KIRKLEES METROPOLITAN COUNCIL INVESTMENT & REGENERATION SERVICE

DELEGATED DECISION TO DETERMINE APPLICATIONS FOR LISTED BUILDING CONSENT

Reference No:	2024/65/92106/E
Site Address:	Wesley House, Huddersfield Road, Birstall, Batley, WF17 9AZ
Description:	Listed Building Consent for alterations to convert former offices to 21 apartments (within a Conservation Area)
Recommending Officer:	Nina Sayers

Officer Report

Proposed Fourth Floor Plan
1:100 @ A1

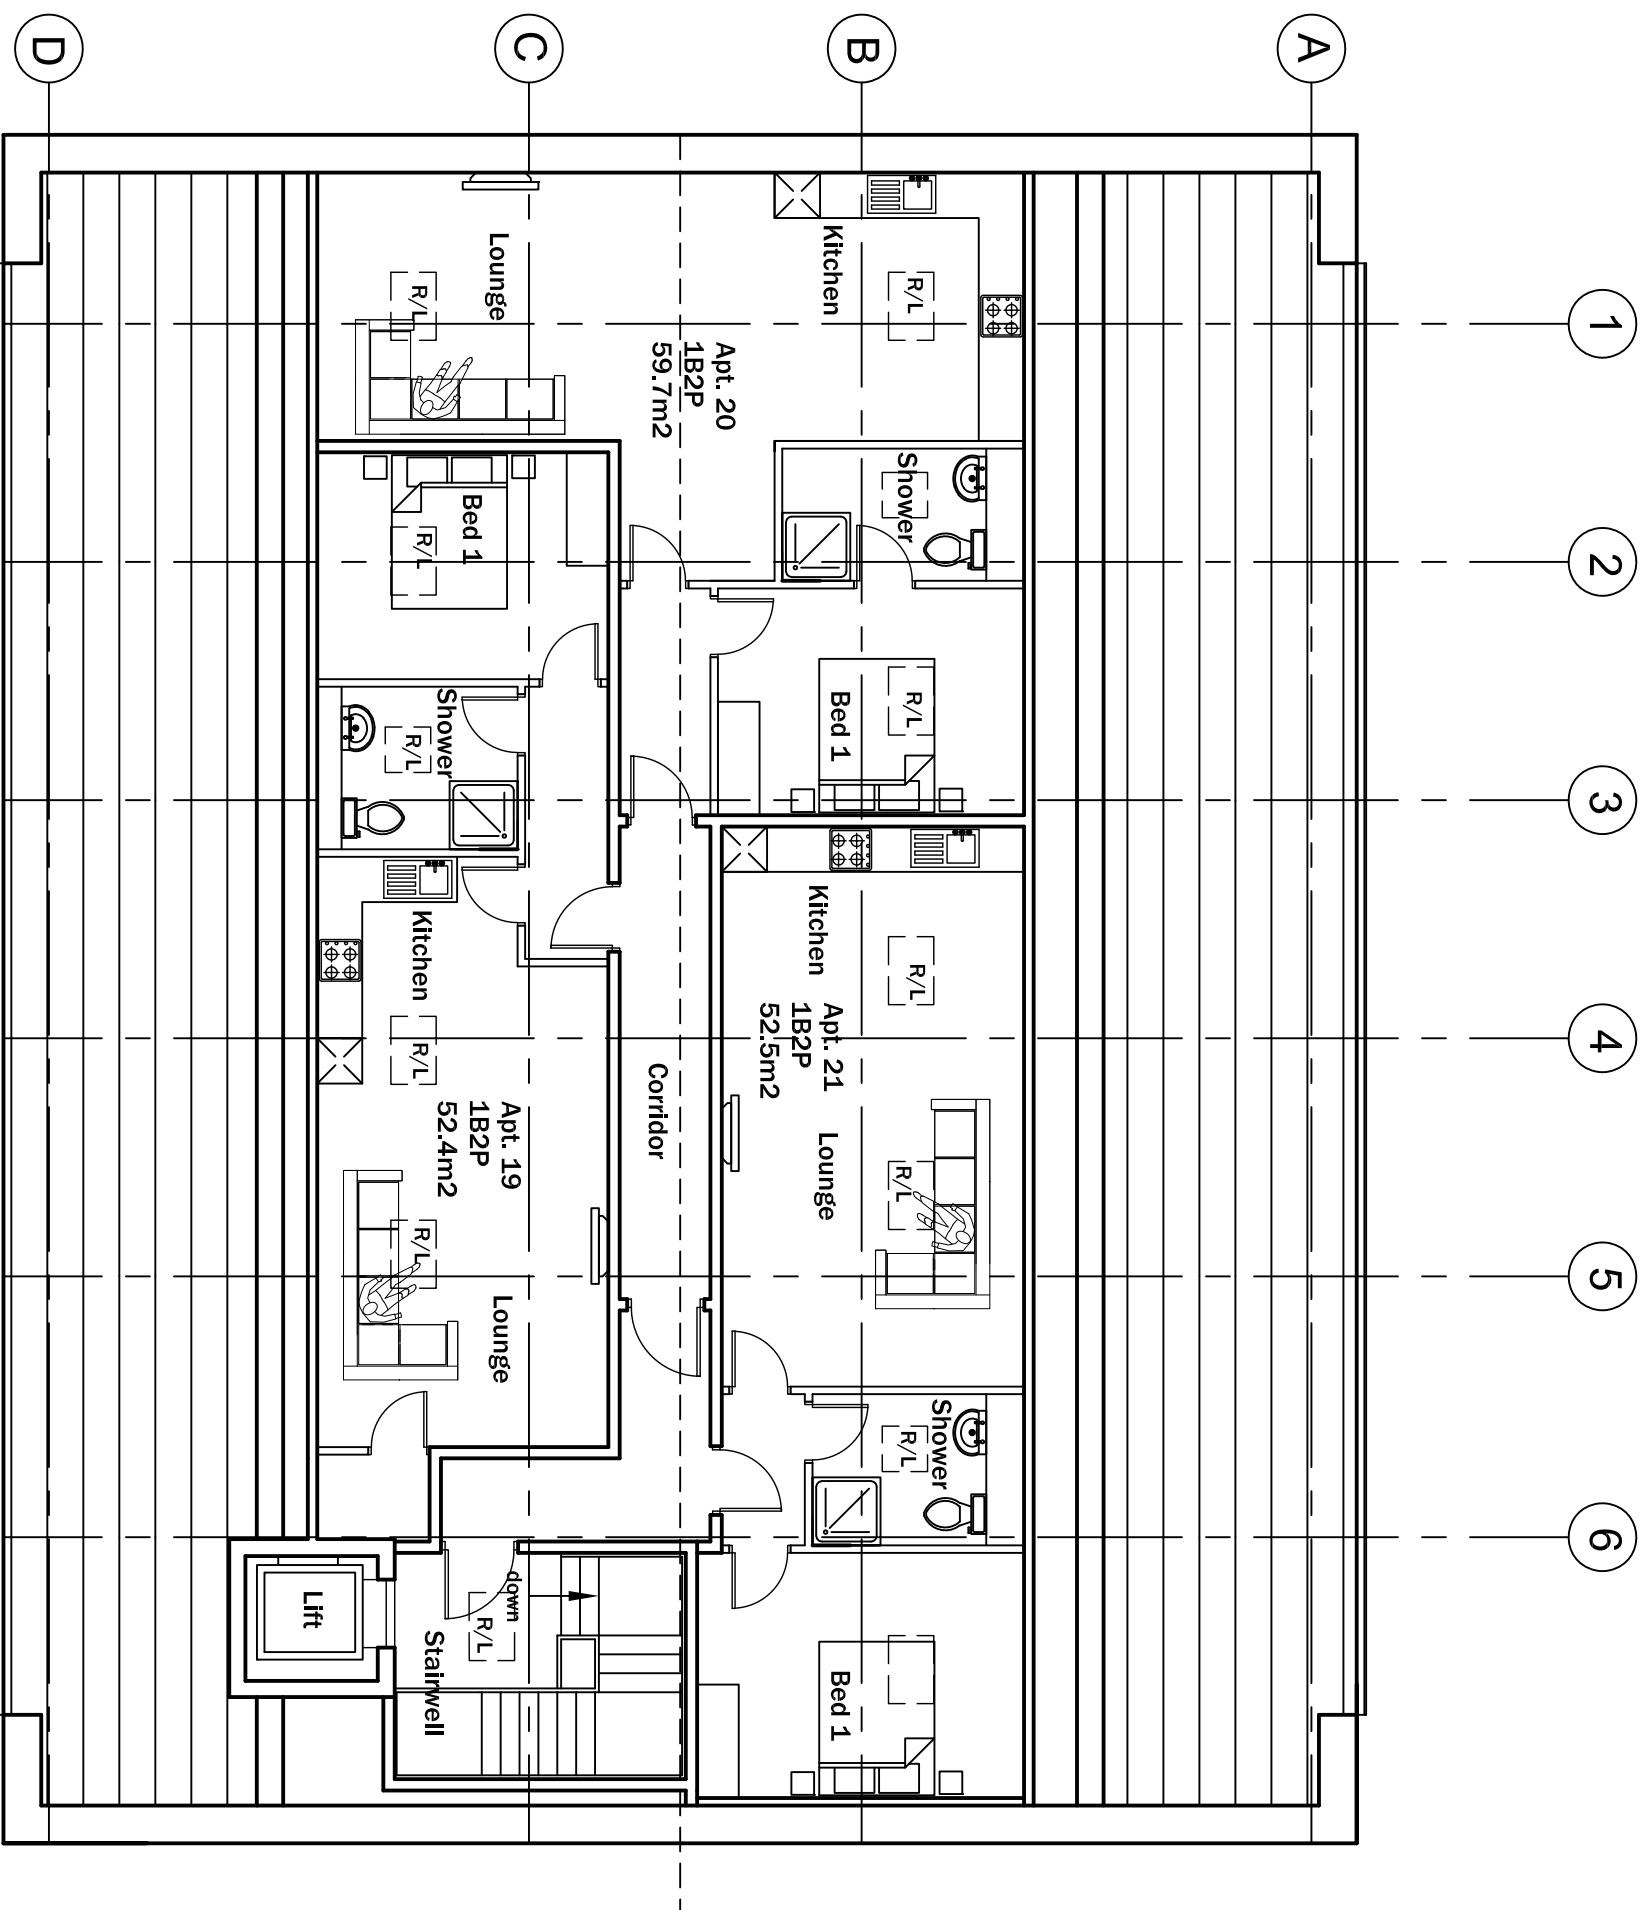
Officers had concerns regarding the ground and second floor living accommodation which is only served by small openings. The applicant

discussed the idea of adding additional openings however, in the interest of preserving the listing building and not causing harm to visual amenity, officers outlined they would not support additional openings. Instead, a revised internal layout was provided which proposed the kitchen area to the lower levels and all other living accommodation to the upper levels which have larger openings.
